# Further Submission on Behalf of Sunyata Retreat Centre Ltd

**Proposed Knockshanvo Wind Farm**

**An Coimisiún Pleanála Reference: ABP-320705-24**

**Response to the Applicant's Response to Observations**

Figure 12-2 Noise measurement locations.

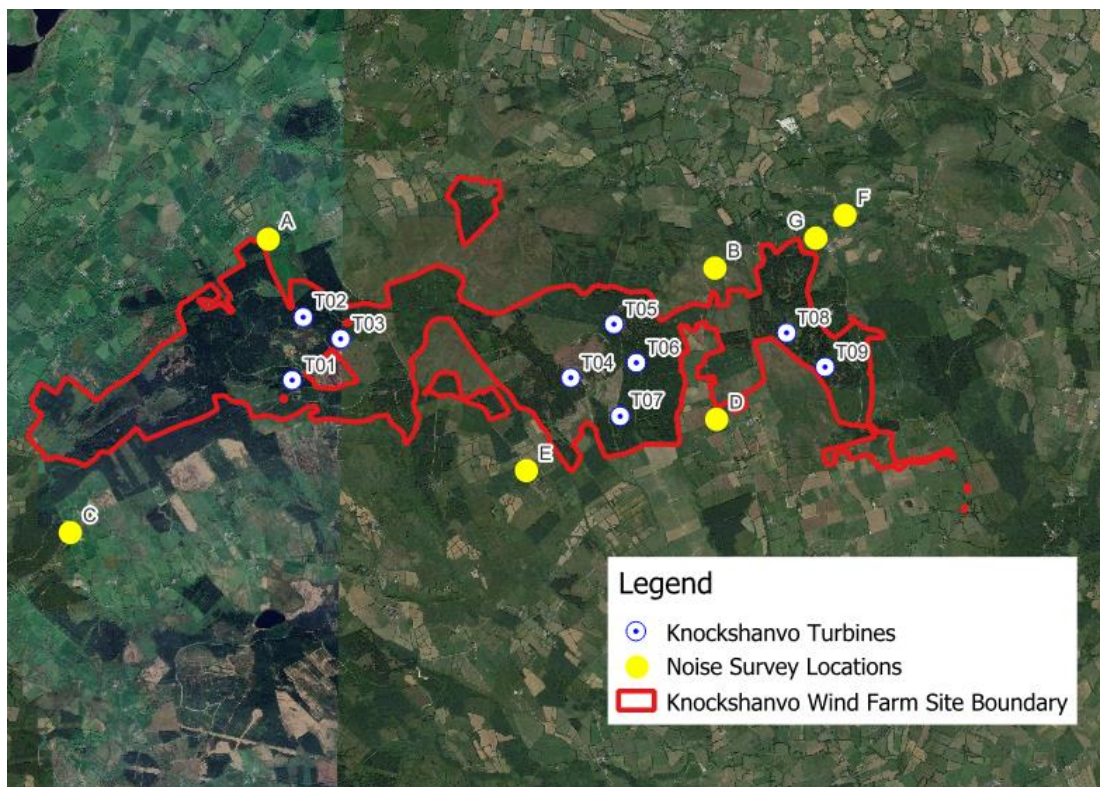
Sunyata appears to have been assessed as Noise Sensitive Location H310.

The Applicant has not identified the exact position, height or acoustic surroundings of H310 or the baseline monitoring position described as Location A.

The response also does not explain:

- why those positions were selected;
- whether they are representative of all sensitive areas within the Centre;
- whether they are affected by road noise, vegetation noise or building screening;
- whether measurements were taken during residential retreats;
- whether the Centre's quietest periods were separately analysed; or
- whether seasonal conditions were adequately represented.
